Department of Primary Industries

OUT17/23689

**Barangaroo Public Domain Works (SSD 7944)
Comment on the Environmental Impact Statement (EIS)**

WATERMANS COVE MASTER PLAN

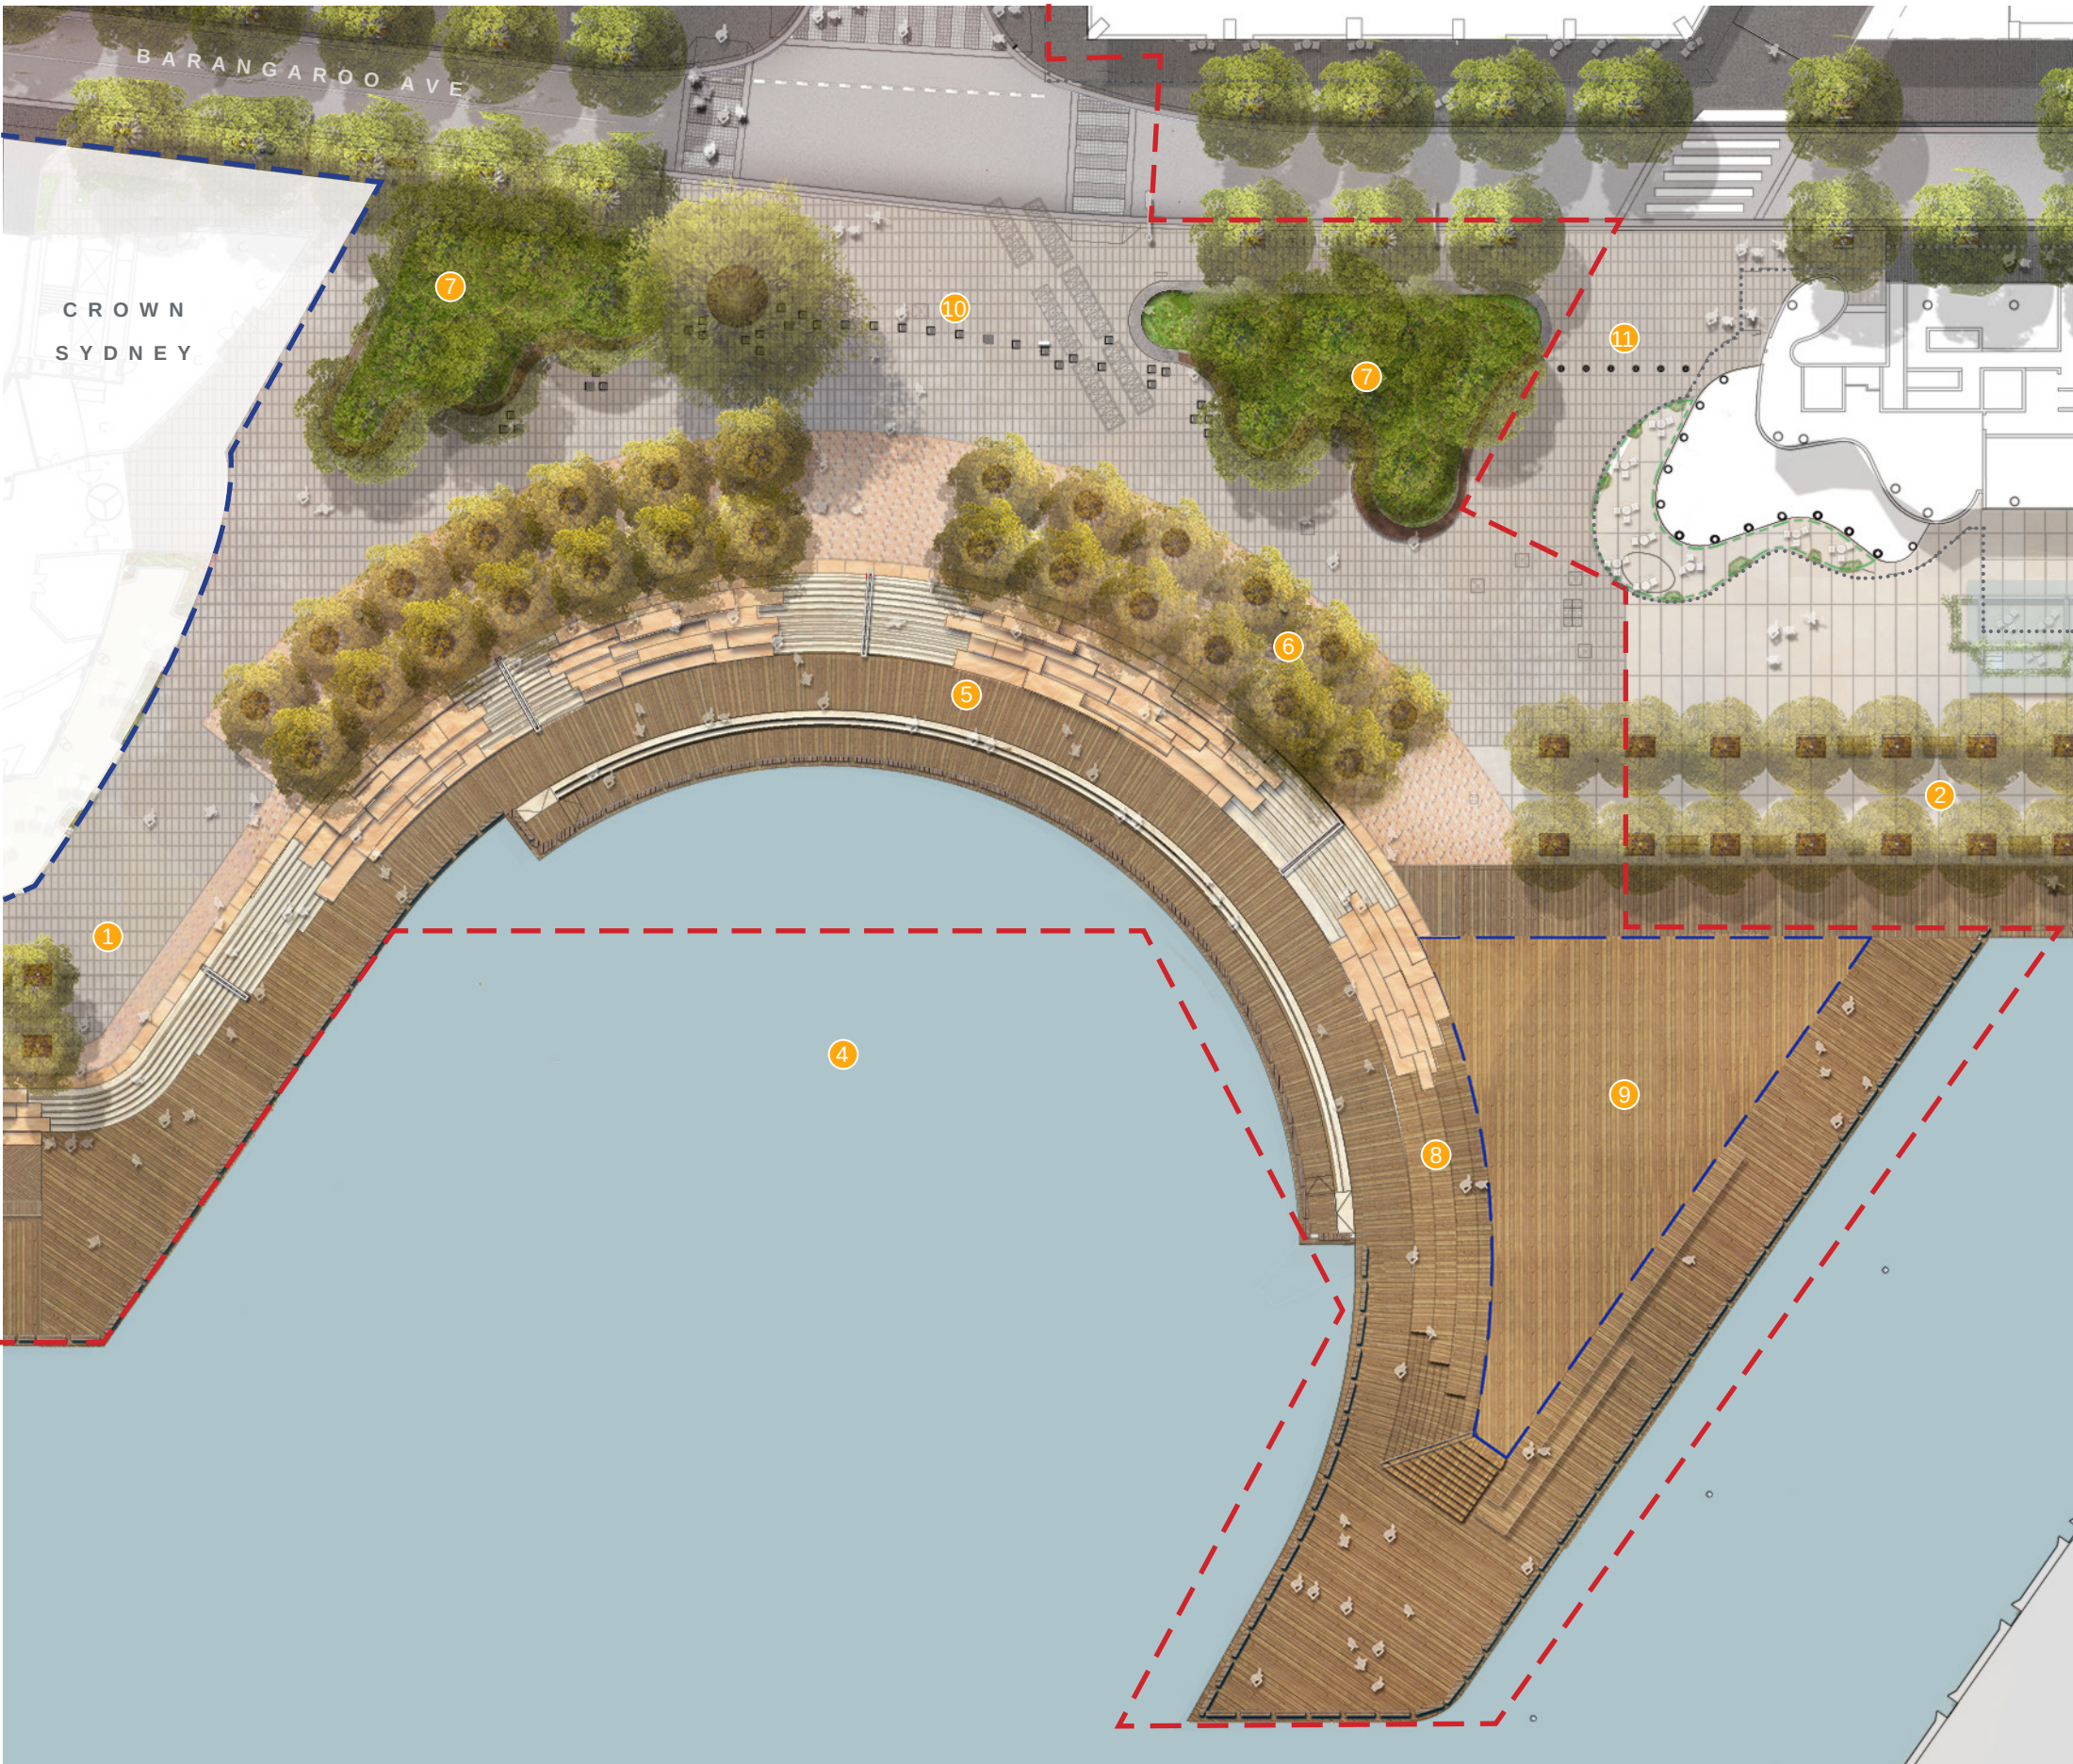
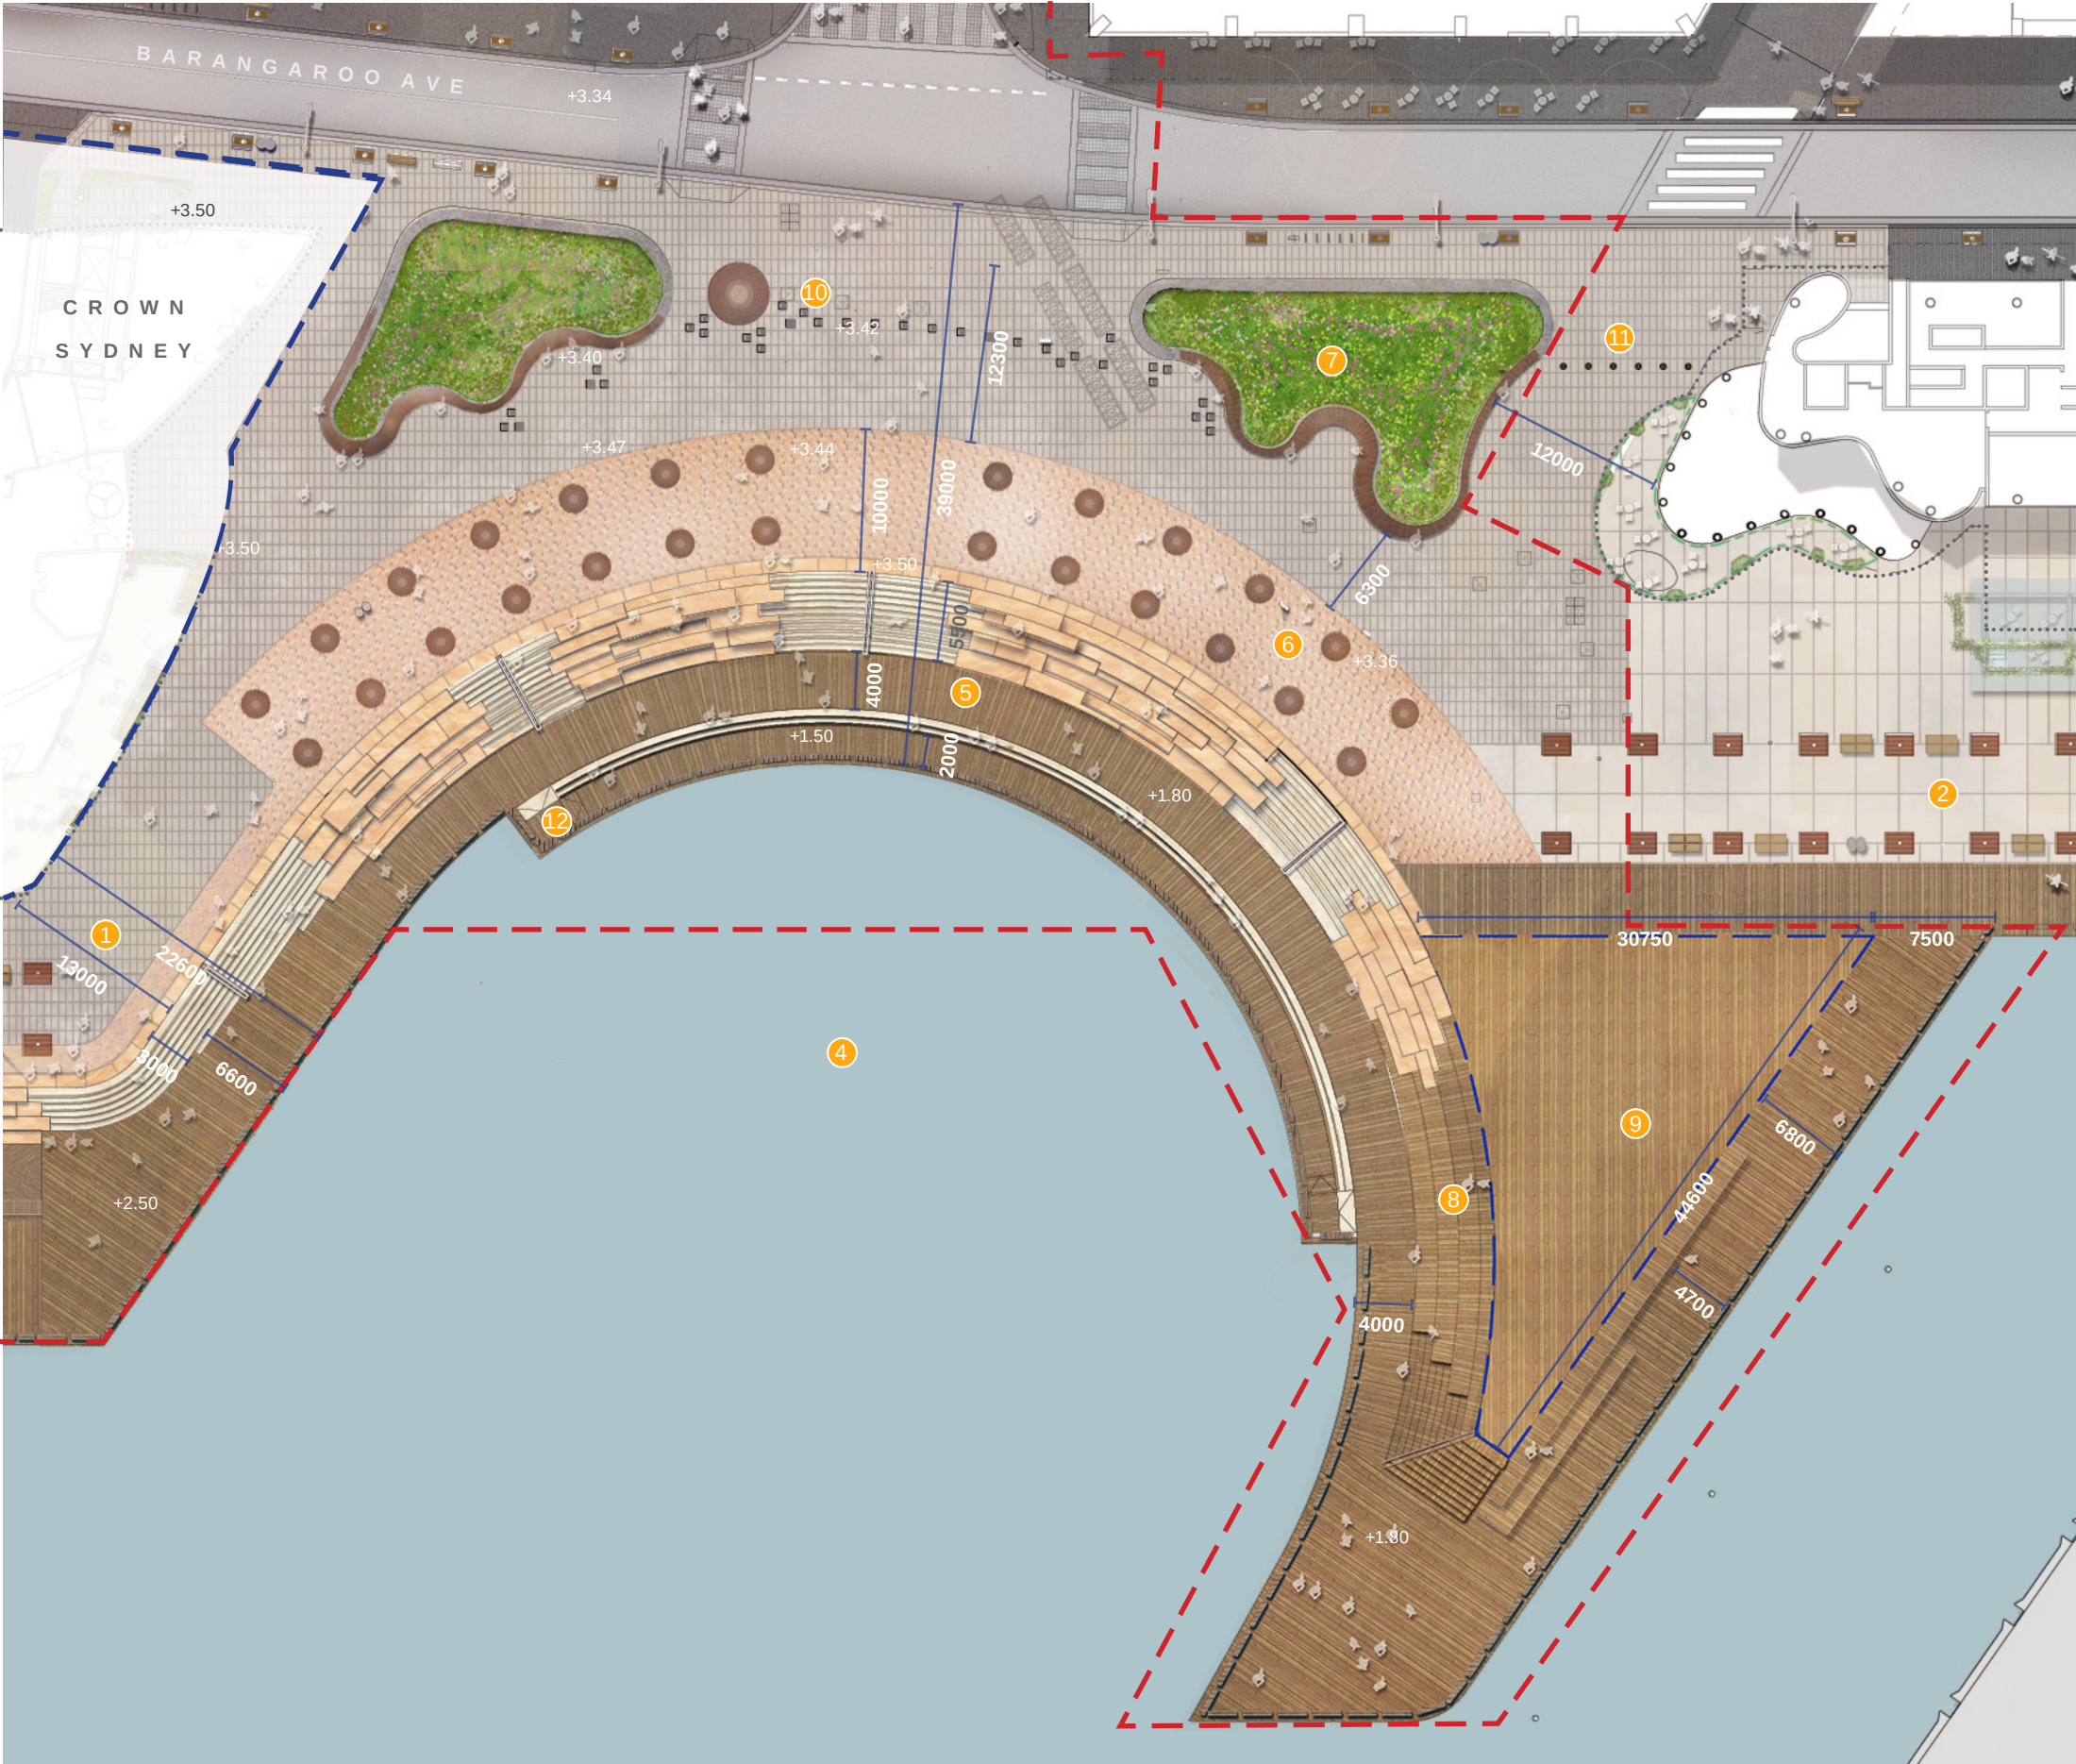
- The proponent should provide further information regarding the stormwater pits adjacent to Watermans Cove and along Wulugul Walk. Specifically, the proponent should advise whether these pits are to be lined, and should provide details on the likely extent of dewatering required including volume, and duration of dewatering.
